# CITY OF ALBUQUERQUE

**Re: Juan Tabo Business Park**  
**1091 Juan Tabo Pl NE**  
**Traffic Circulation Layout**  
Engineer's Stamp 04-12-23 (G21-D021)

Based upon the information provided in your submittal received 04-18-23, the above referenced plan cannot be approved for Building Permit until the following comments are addressed:

ENGINEER'S SEAL	JUAN TABO BUSINESS PARK ALBUQUERQUE, NM	DRAWN BY JL
	TRAFFIC CIRCULATION LAYOUT	DATE 05-09-2023
	TIERRA WEST, LLC 5571 MIDWAY PARK PL NE ALBUQUERQUE, NEW MEXICO 87109 (505) 858-3100 www.tierrawestllc.com	DRAWING 2022122-TCL
		SHEET # TC-1
		JOB # 2022122

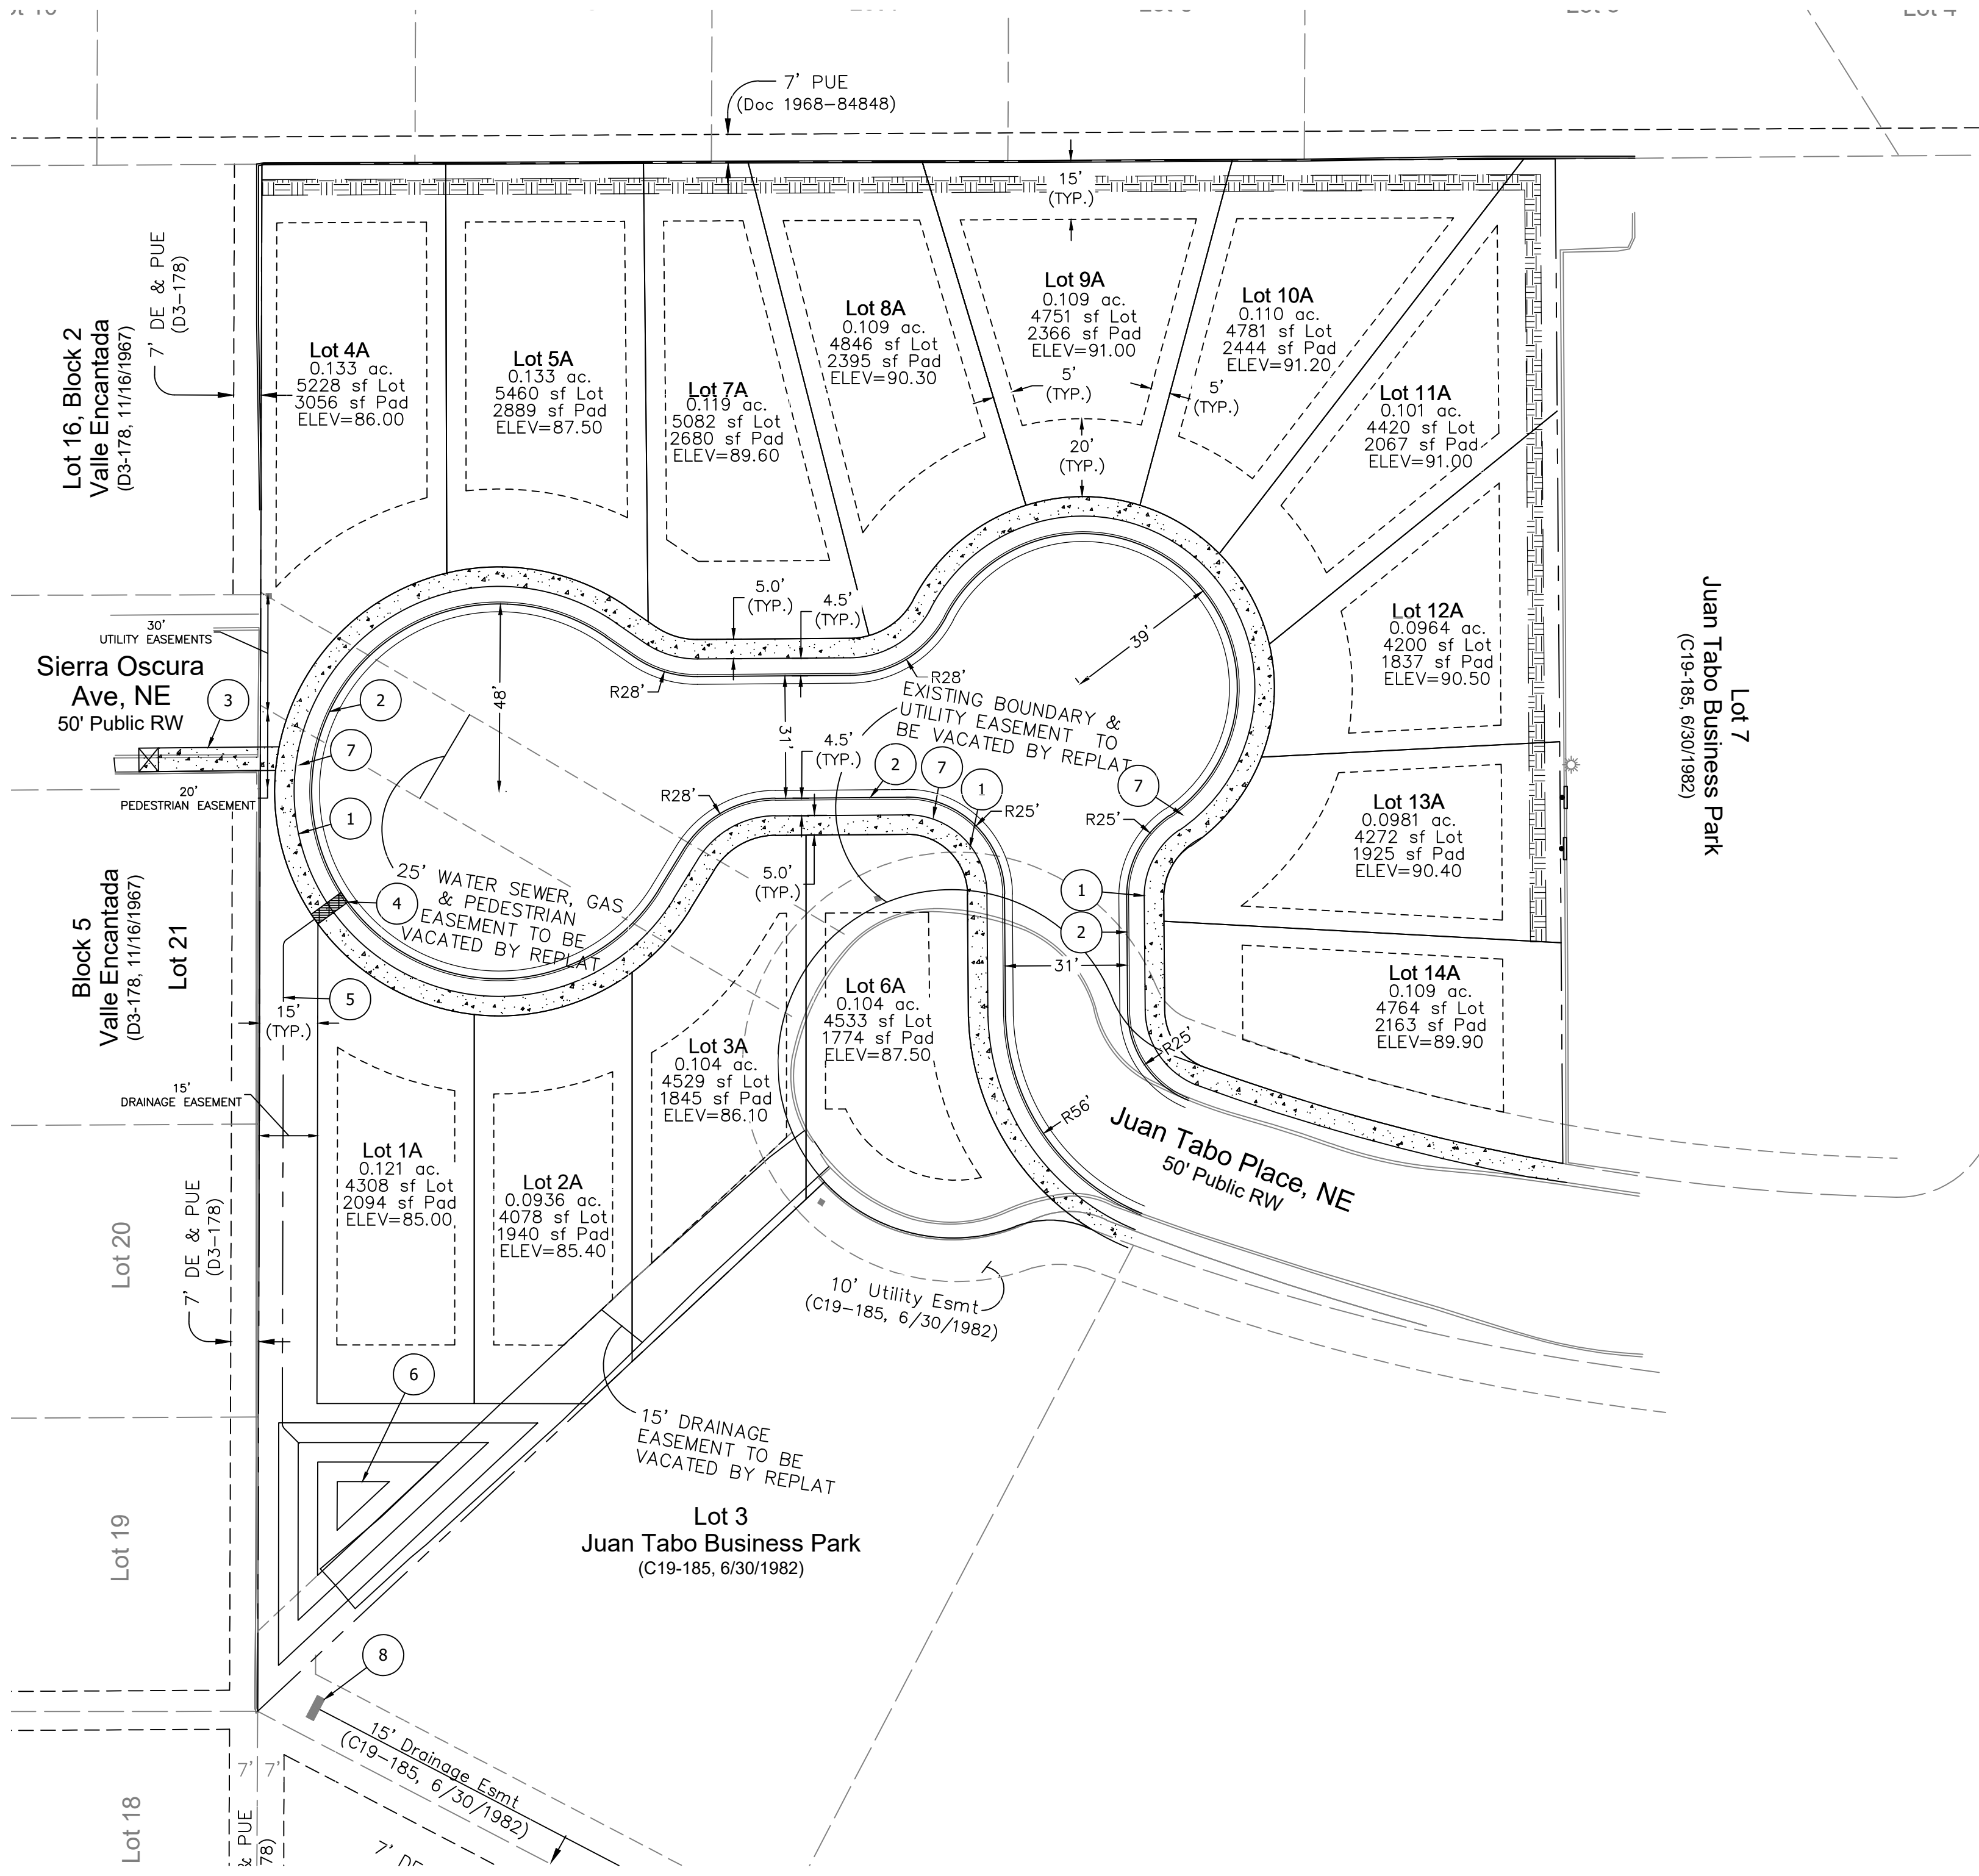
1. Identify all existing access easements and rights of way width dimensions.
2. The proposed cul-de-sac diameter does not meet current standards for a turnaround. Please see attached and follow the design guidance.
